From: Neil Whitton  
Sent: 15 July 2020 09:28  
To: Bob Neville <Bob.Neville@cherwell-dc.gov.uk>  
Cc: DC Support <DC.Support@cherwell-dc.gov.uk>  
Subject: RE: 20/01581/F - Cotefield Business Park

Environmental Protection has the following response to this application as presented:

Noise Details :

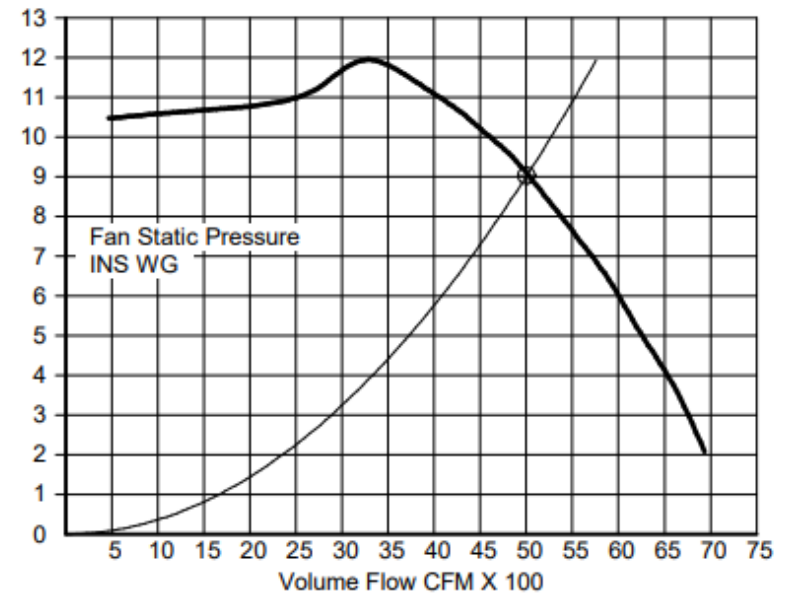
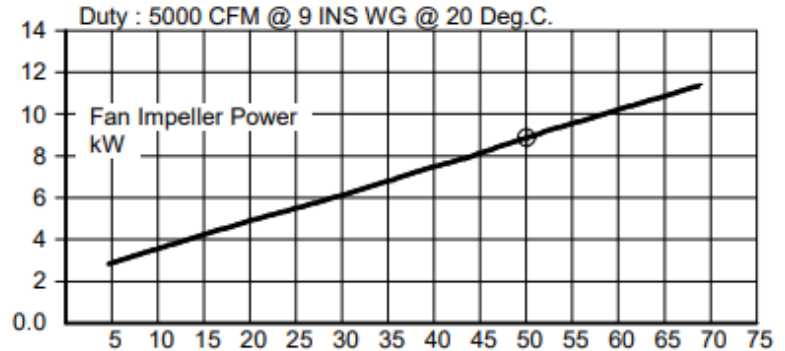
My comments on noise still stand though as despite the email from the installer stating that the noise levels are lower than what is stated they can't provide any evidence on how low they will be with the "silencing scroll" and attenuator pods.

Noise: Having reviewed the information provided the noise levels seem very high. Therefore I would like the following condition to be placed on any permission granted:

A noise report produced to BS4142:2014 shall be produced and approved by the LPA. Any mitigation required by the report shall be in place prior to the first occupation of the units.
